Re: Letter of Intent

YES Communities – Antelope Ridge Home Park; Storage Yard to Residential Lot Conversion PUD

PUD
Amendment
(PUD98-003)

SITE PLAN

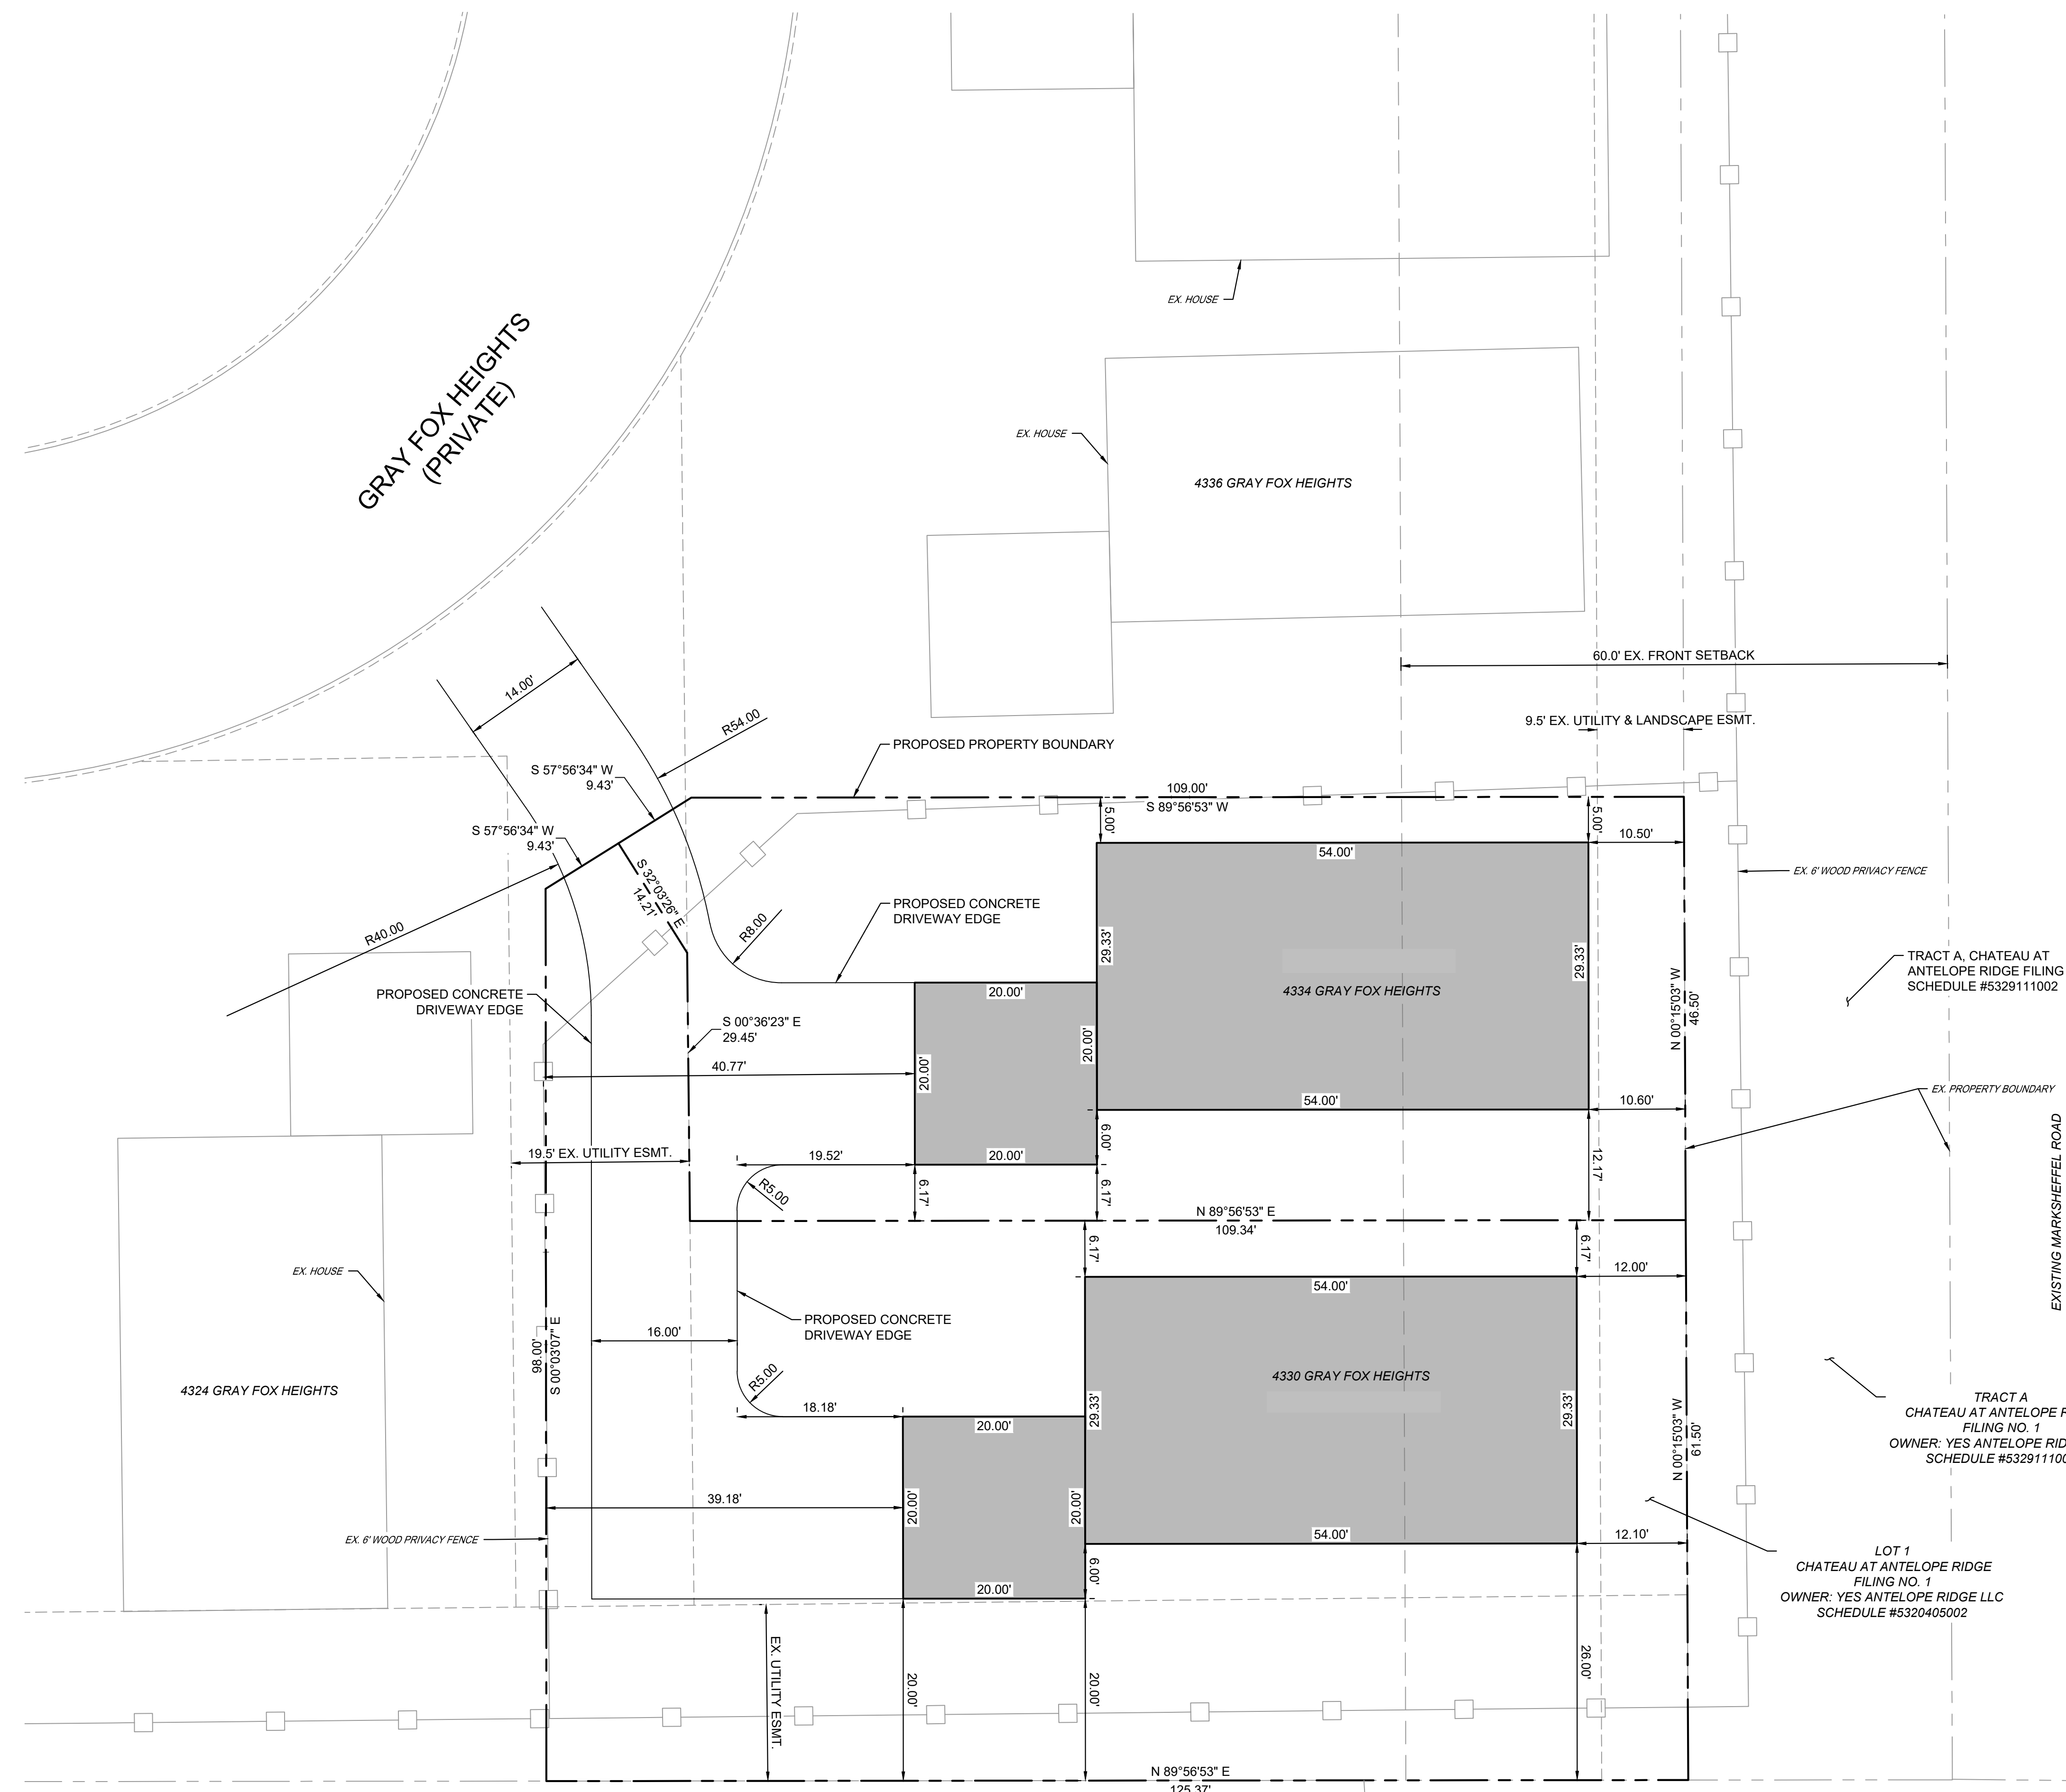
Please include a discussion about which residential lot will not be used.

It was explained to staff that a current residential lot will not be used and this storage yard will be transitioned into 2 lots. thus no technical lot increase. Please include this discussion.
